Sizewell C Written Representation – Deadline 2

Mark Beaumont – Interested Party

2 June 2021

Following my Relevant Representation dated 30-Sep-20, I raise the following areas of significant concern over the Sizewell C Application specific to the proposed Sizewell Link Road (Work No. 12B) (“SLR”) and Theberton Hall, which have not been addressed by the applicant.

DRAWING TITLE:
SIZEWELL LINK ROAD
PRETTY ROAD JUNCTION
PROPOSED GENERAL ARRANGEMENT

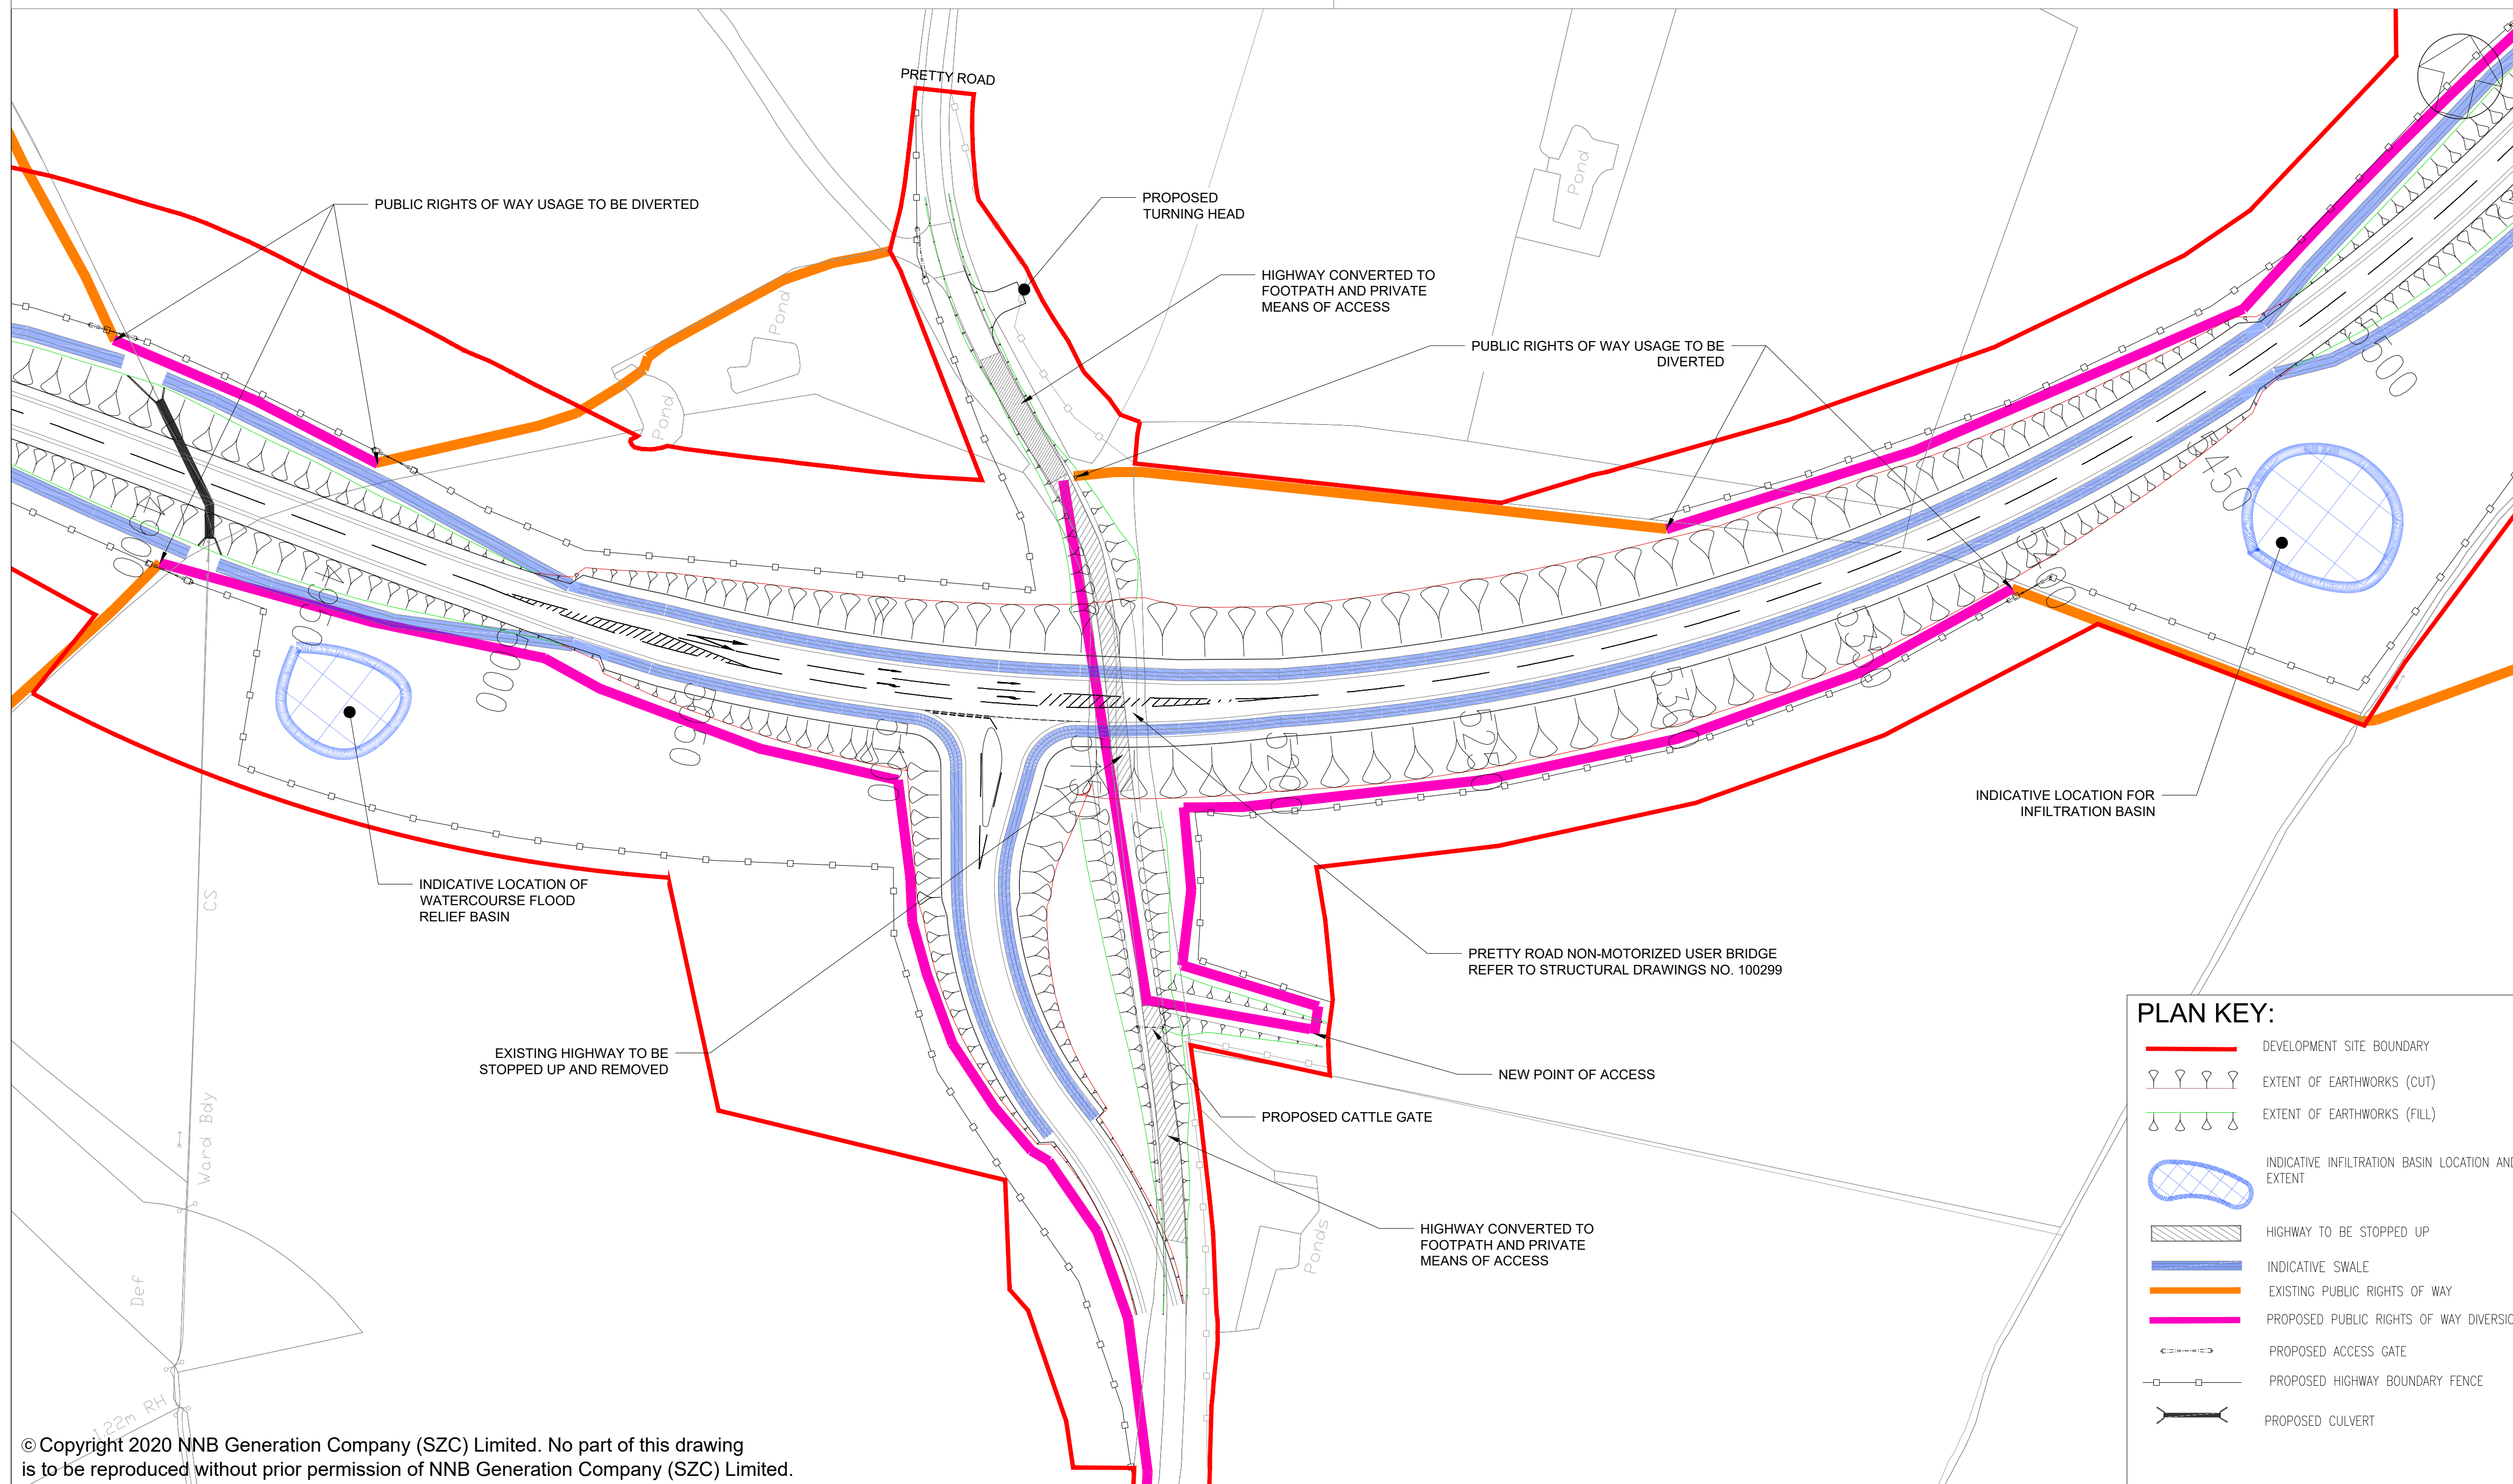
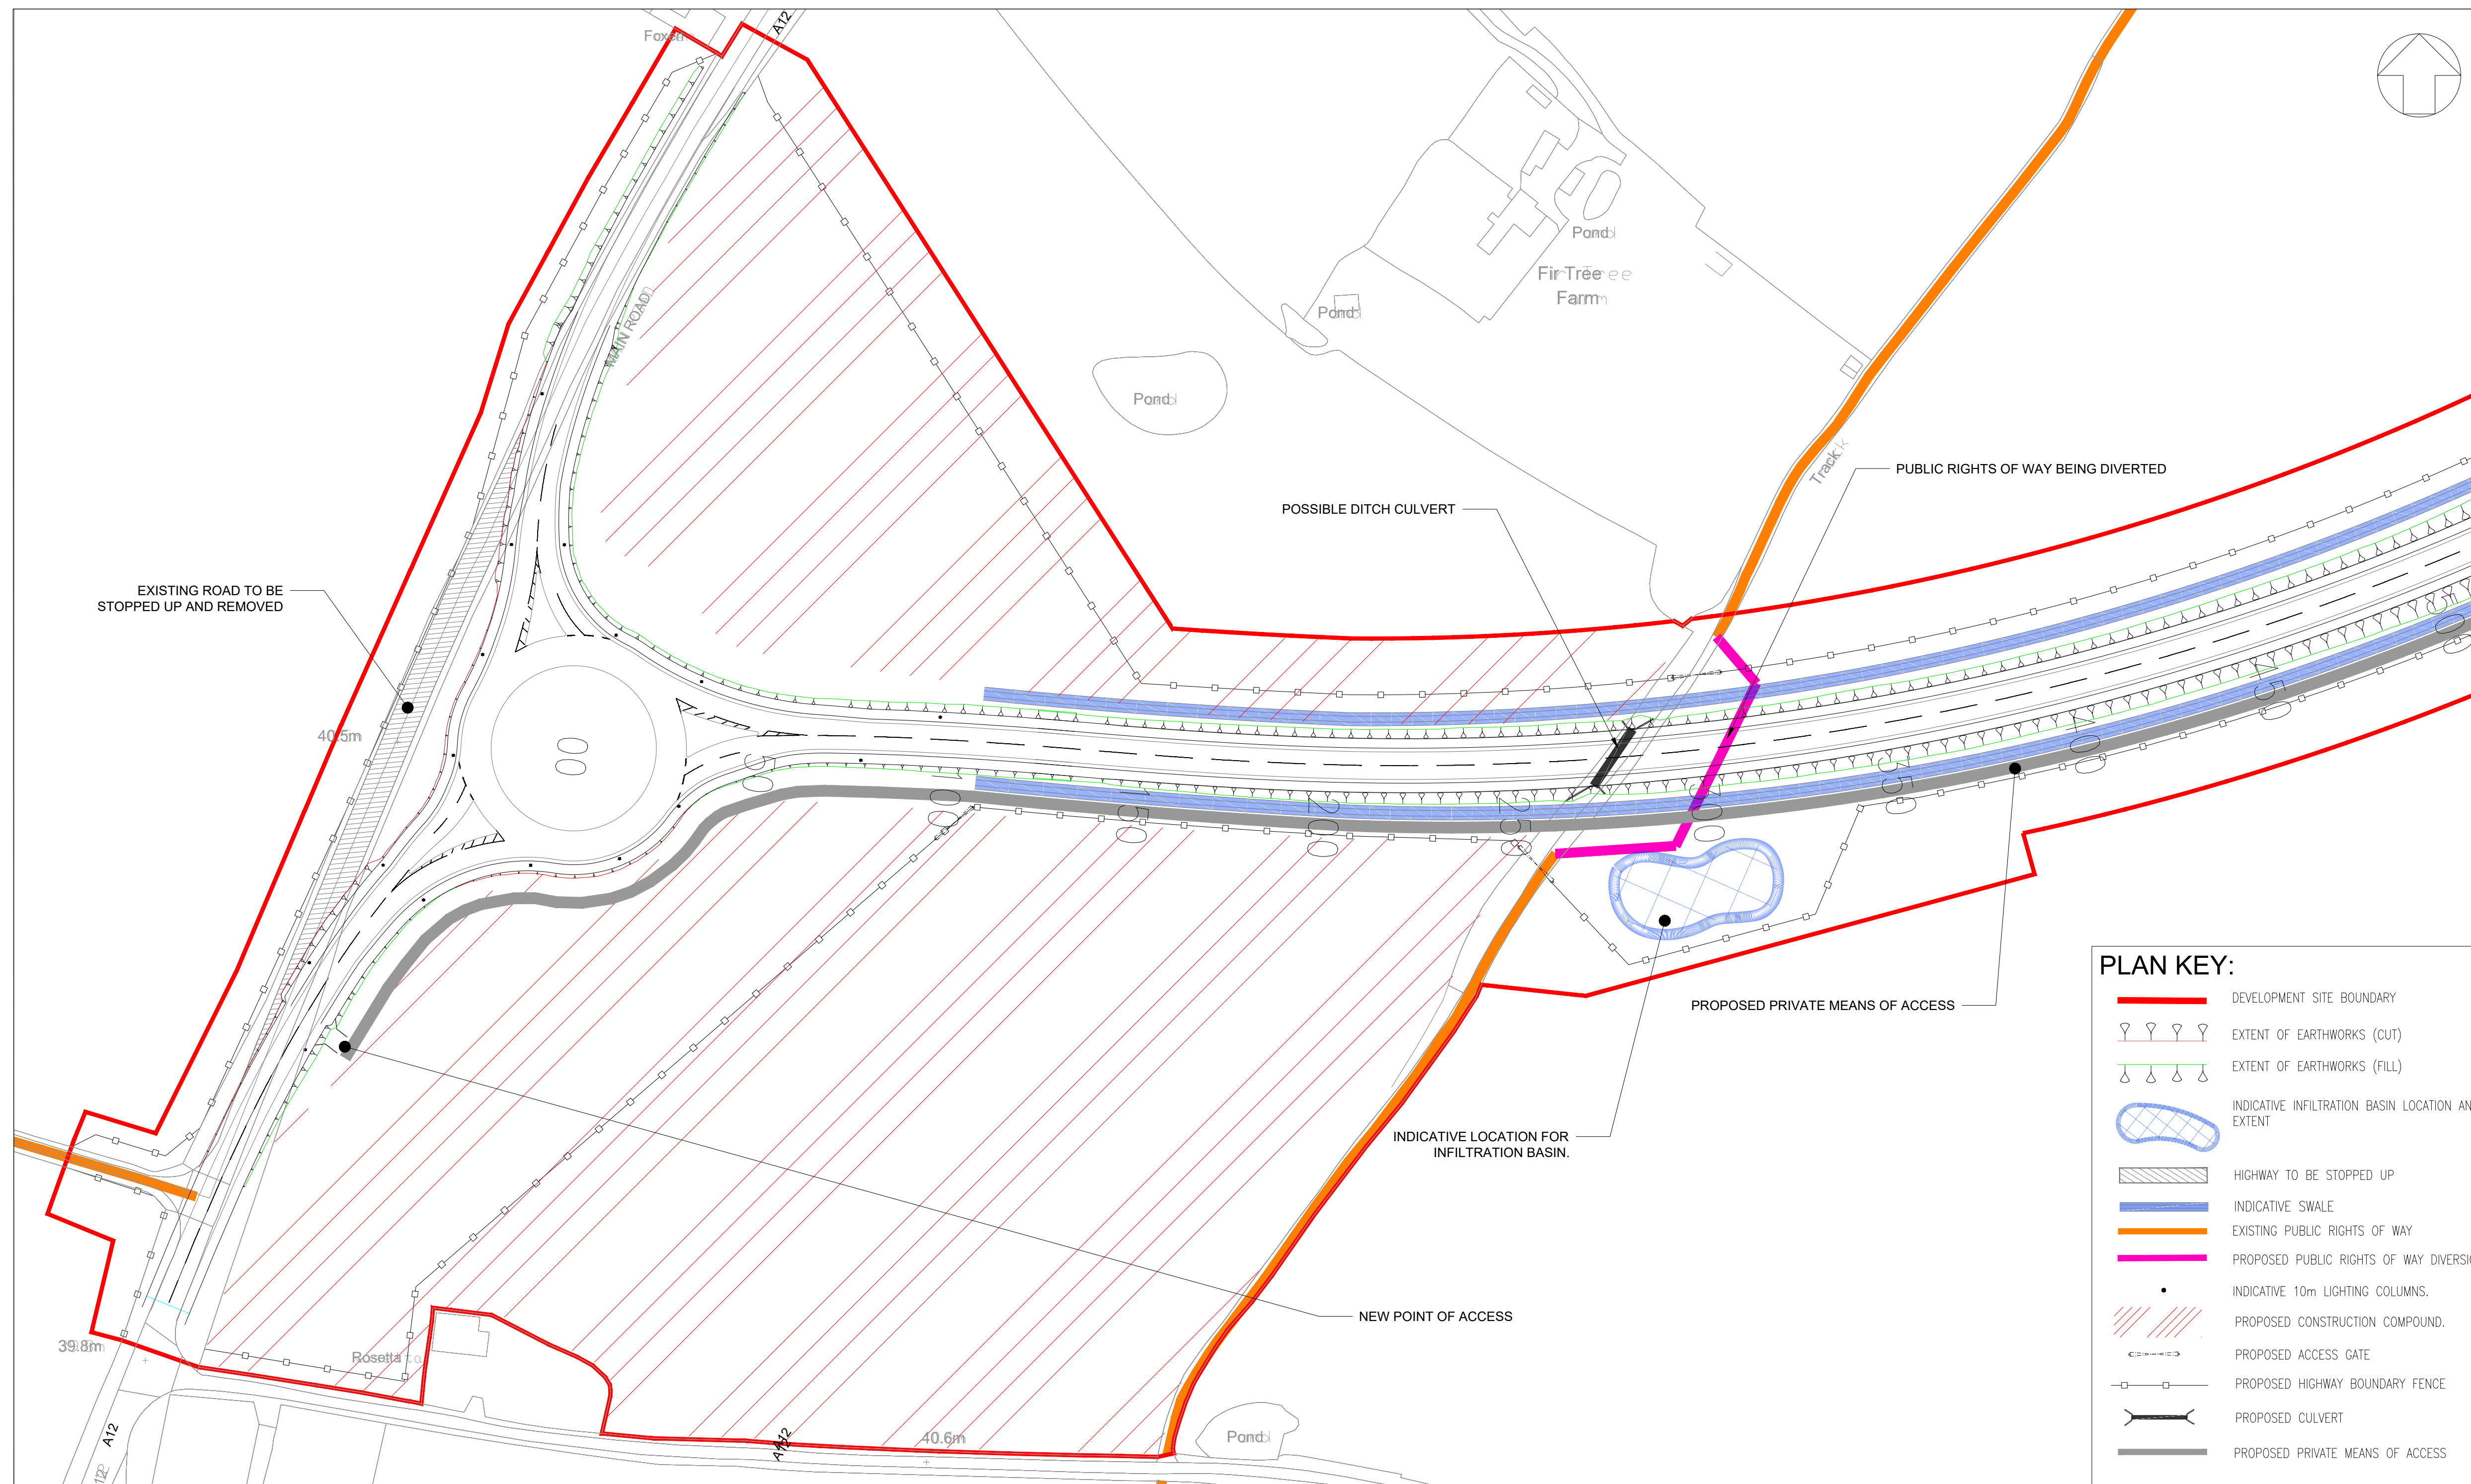
3. SLR – Pretty Road Stopping Up – Junction Not Fit for Purpose

- EDF is proposing to stop up Pretty Road and limit crossing to pedestrians, cyclists and horses. Whereas 99% of traffic on Pretty Road is vehicular. In 25 years, I have only seen a horse on Pretty Road once or twice.
- EDF has not commented on this in the RRR despite acknowledging this being raised as an issue by multiple stakeholders.
- If the SLR is pursued, vehicular access on Pretty Road must be maintained (via a vehicular bridge) in order not to sever the local community and their access to Saxmundham. To do otherwise and prioritise horses over vehicles on this road, makes absolutely no sense.
